From: Tim Rodway | Rodway Planning [REDACTED]
Sent: 25 April 2019 11:14
To: Andrew Wood; Planning
Subject: Application LU/91/19/PL - Representation

Planning application reference: LU/91/19/PL

Change of use of parts of seafront for temporary food & drink outlets & other seaside uses together with associated temporary/portable structures & equipment for use by businesses associated with those outlets. Various sites along Littlehampton Promenade, Littlehampton

1.0 Introduction

SITE LOCATION PLAN AND
BLOCK PLAN - SITE C&D

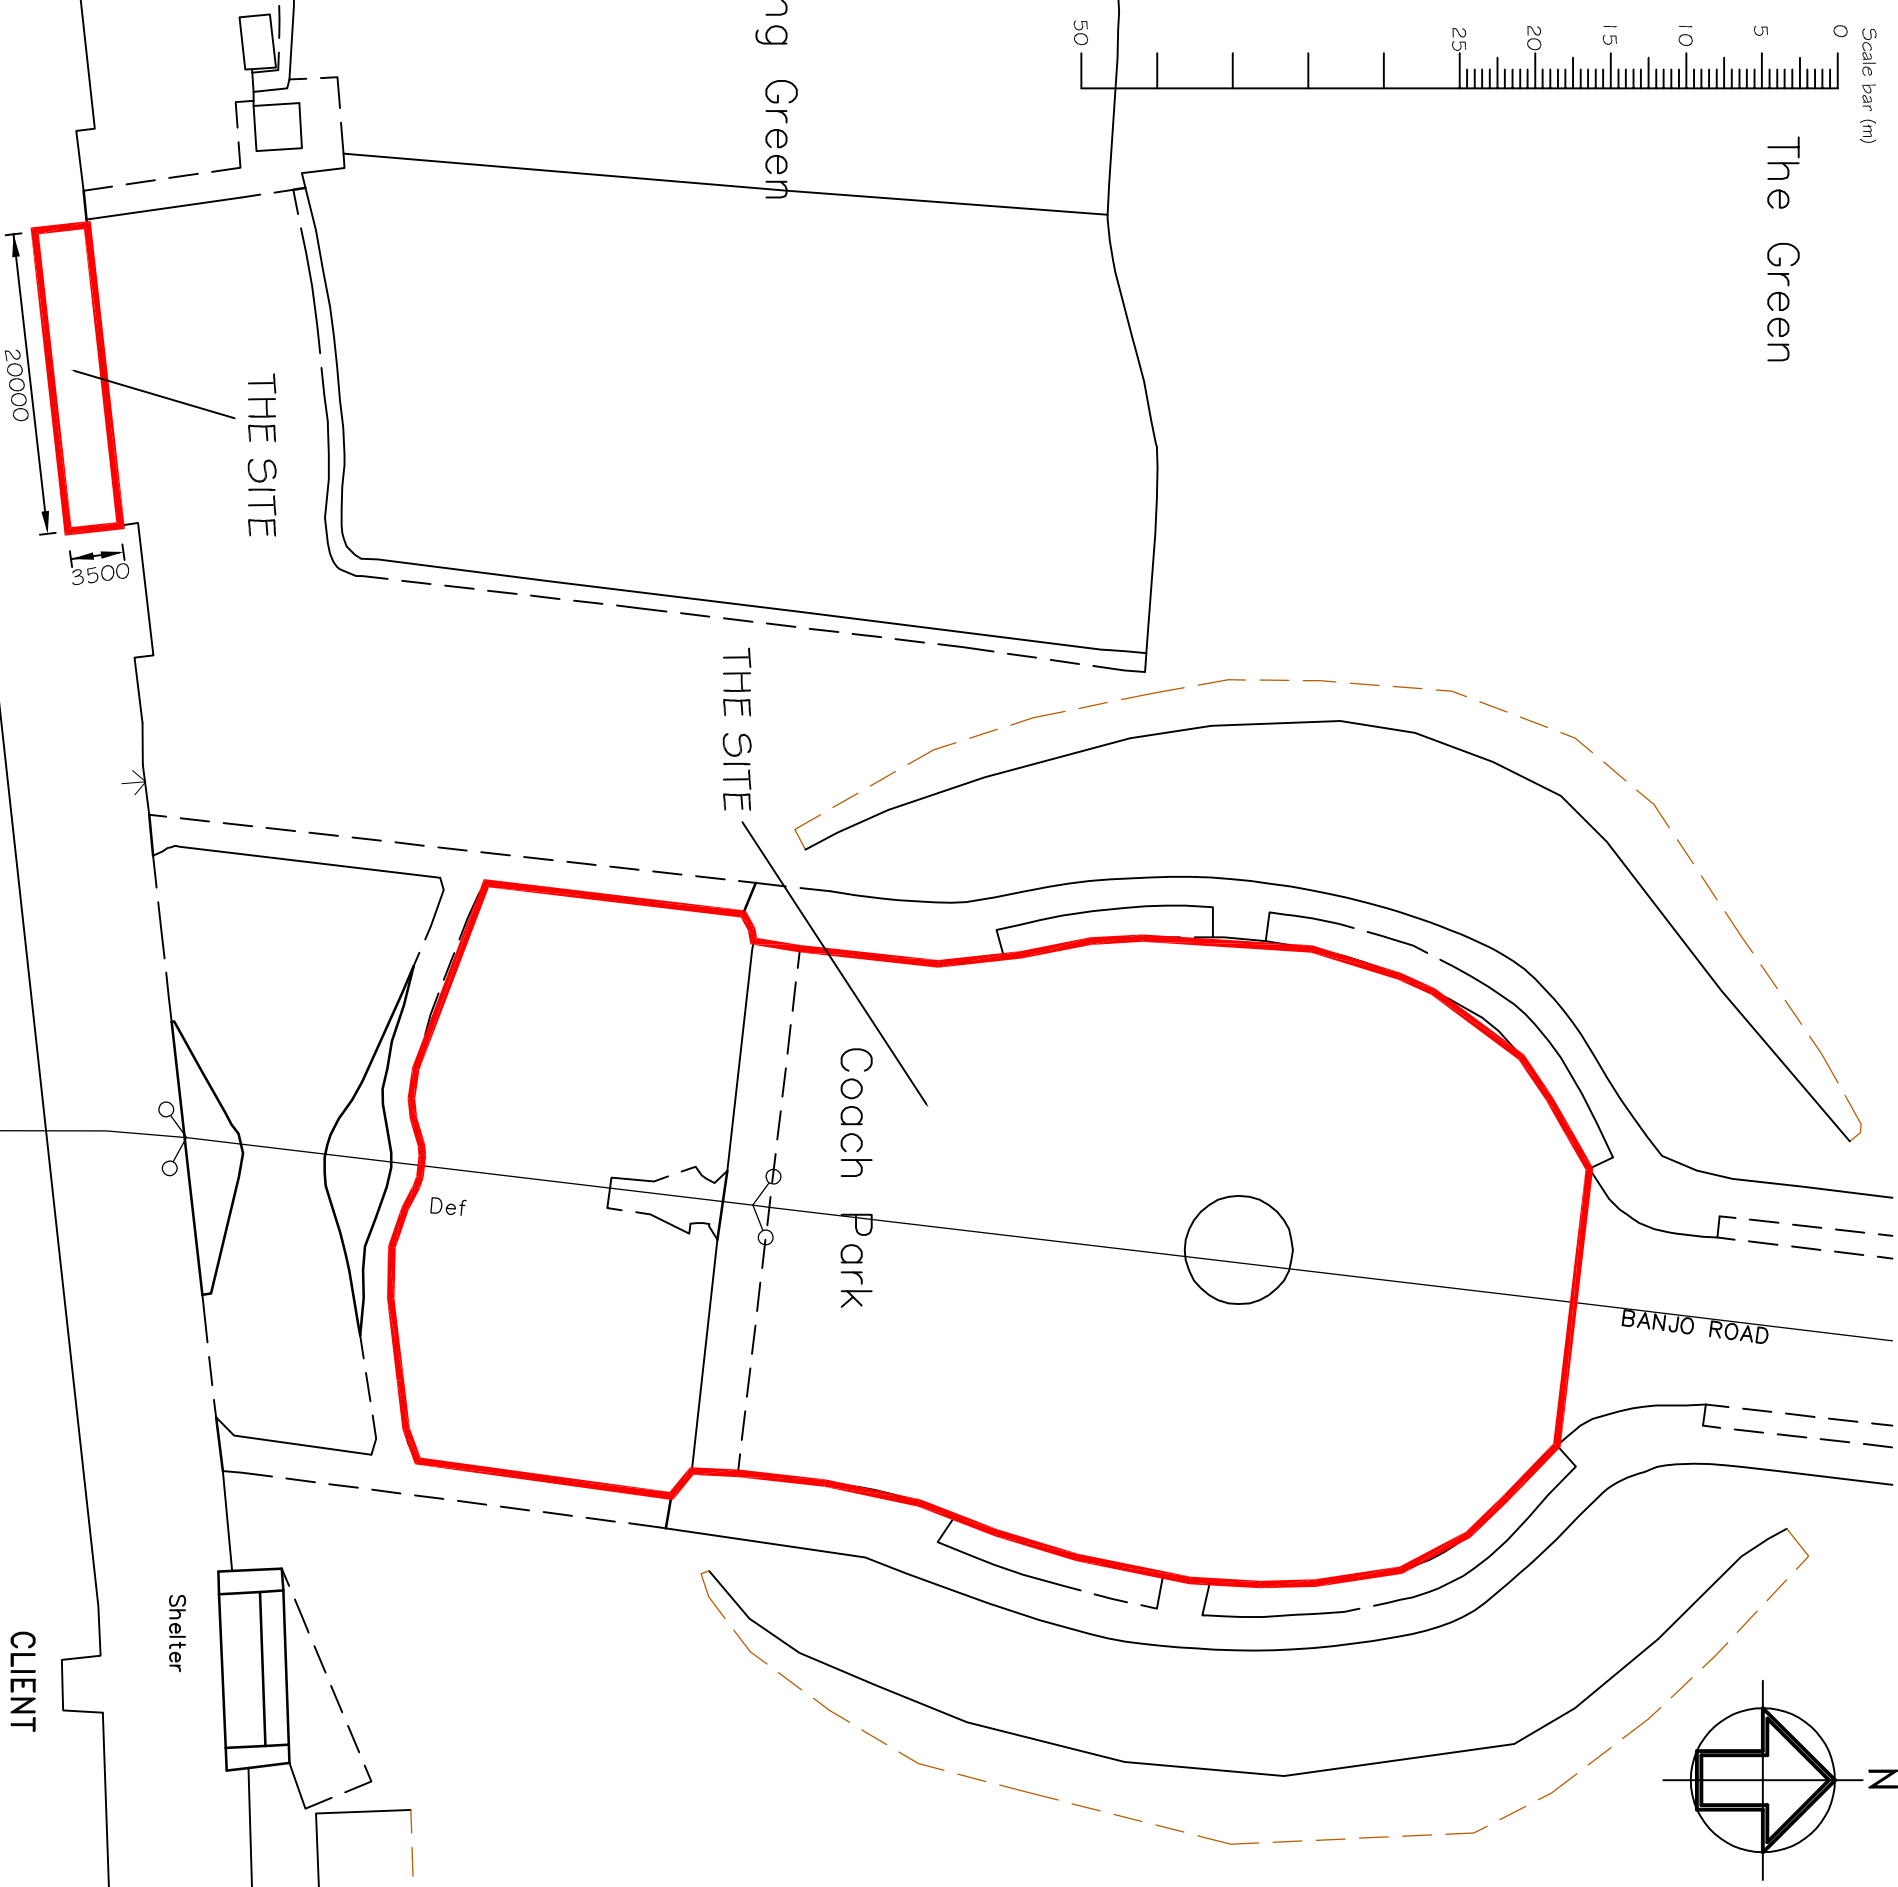
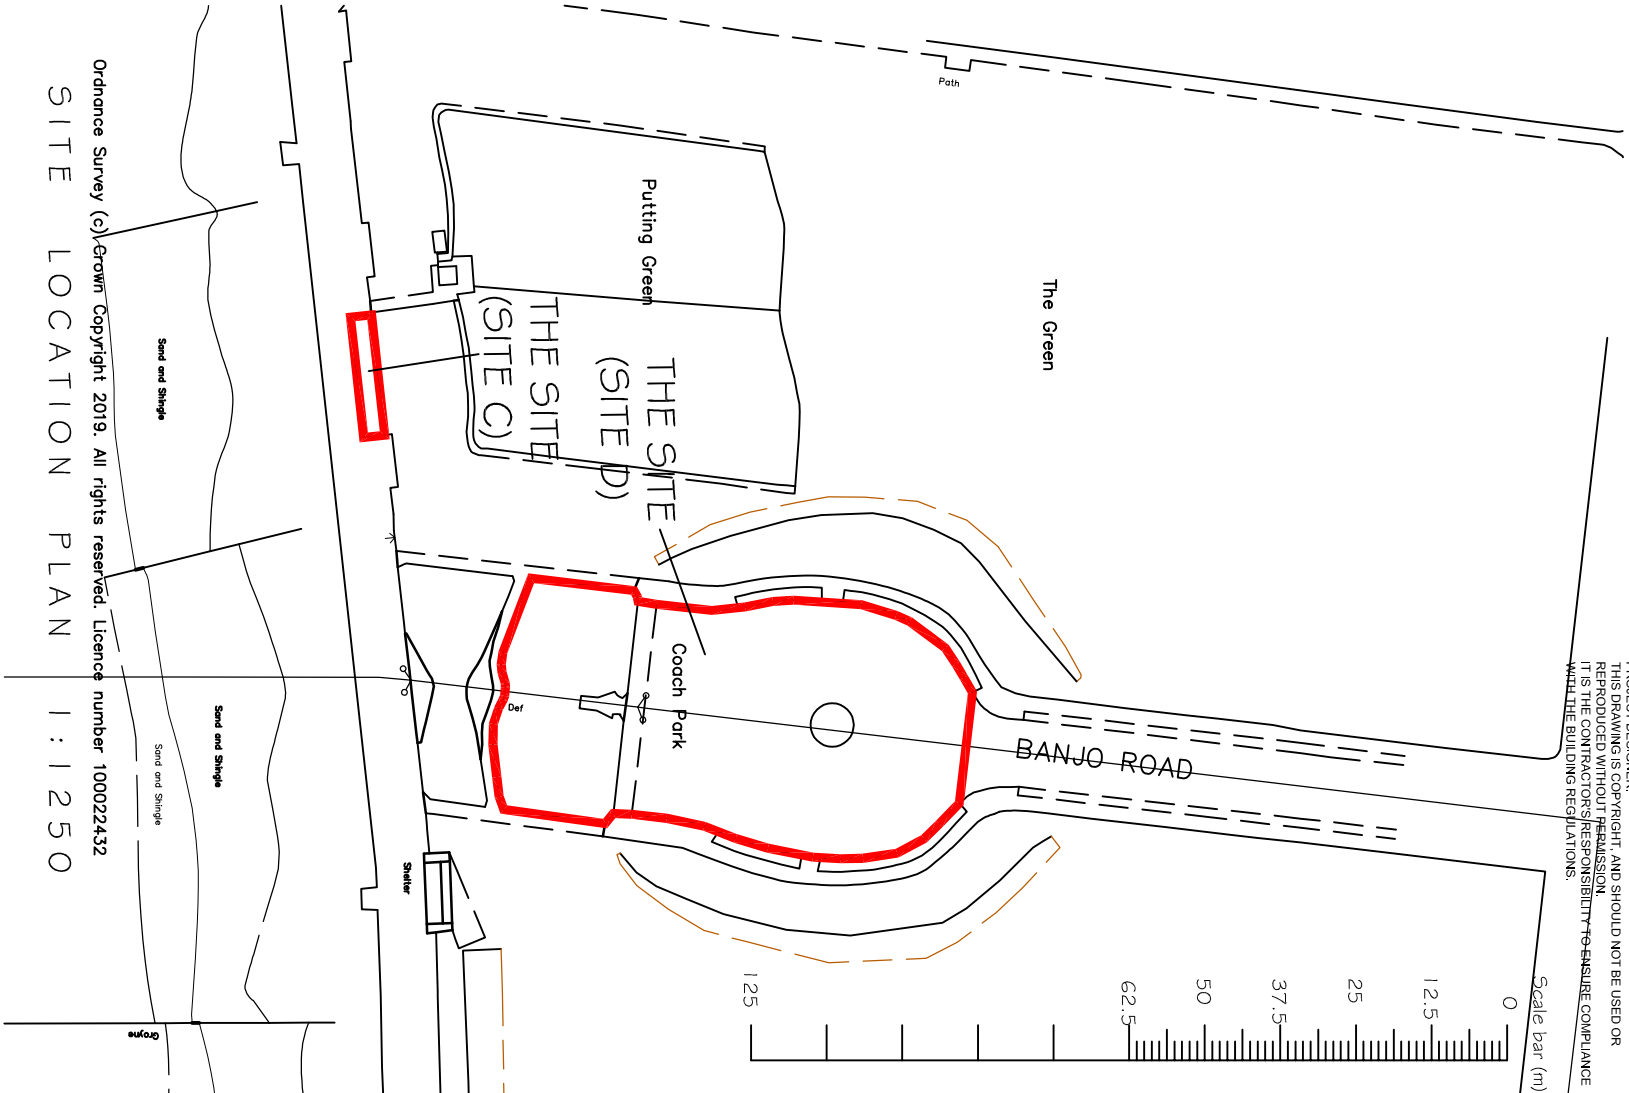
- 3.12 Given the similarity of these two sites that are located on the existing promenade, it seems sensible to consider these together. As with Site B (above), these sites are in prominent and important locations, situated on the popular promenade located at the back of Littlehampton’s East Beach. As existing this area is well served by existing outlets, including the East Beach Café, and other facilities associated with Harbour Park.

- 3.13 According to the submitted details, both sites incorporate an area of the existing promenade measuring 20 metres long by 3.5 metres deep. This will create a significant narrowing of the existing width of the promenade, and we are concerned how this will impinge on this well used thoroughfare, which is integral to Littlehampton's charm and tourist offer. The promenade is used by pedestrians, cyclists, the motorised prom train, and servicing vehicles. If development is approved at Sites C and E, this activity will continue, but in very close proximity to the (presumably) new kiosks. In busy periods, queues of people will spread onto the non-demarcated promenade creating a further narrowing of the public thoroughfare and significantly impinging on access.

- 3.16 The above photographs show the existing motorised road trains that run along the promenades at Bognor Regis (Figure 5), and Littlehampton (Figure 6). Figure 5 shows the road train at the site of a kiosk on Bognor prom at its narrowest point. The promenade is 1.5 metres wider than that proposed for Littlehampton, and as can be seen from the above image, this is very tight. Indeed, it is common knowledge amongst traders and the Foreshore Officers that this train has difficulties in passing this route when the promenade is busy. Importantly these measurements do not allow for any queues, refuse bins, or other paraphernalia that would be associated with a kiosk in this location. Put simply, the promenade is not of sufficient width to accommodate kiosks in the locations proposed. To provide such outlets would create congestion at best, and at worst would lead to significant public safety issues.

- 3.23 Finally Policy D DM1 requires that in terms of scale the proposals should be in keeping with the local context. We consider that the application would clearly fail in this respect. The 20 x 3.5 metre size of the kiosks proposed for Sites C and E could also lead to a density/mass of

- 3.24 This site is the existing coach park, which is well used in busy periods. It is an open area, which is surrounded by designated open space. To fill this area for an unspecified period with kiosks or other outlets would lead to the degradation of the areas defining visual qualities.

- 3.25 Arguably of even greater importance is that if the entirety of the area proposed is used for commercial purposes, then what will be done to accommodate the displaced coaches that currently utilise this area? This is an important local facility, which coach operators are attracted to due to its ease of use, size and proximity to the beach and nearby attractions – which is a commodity in such a coastal location. These coaches bring many much-needed tourists to the area, who support the existing businesses.
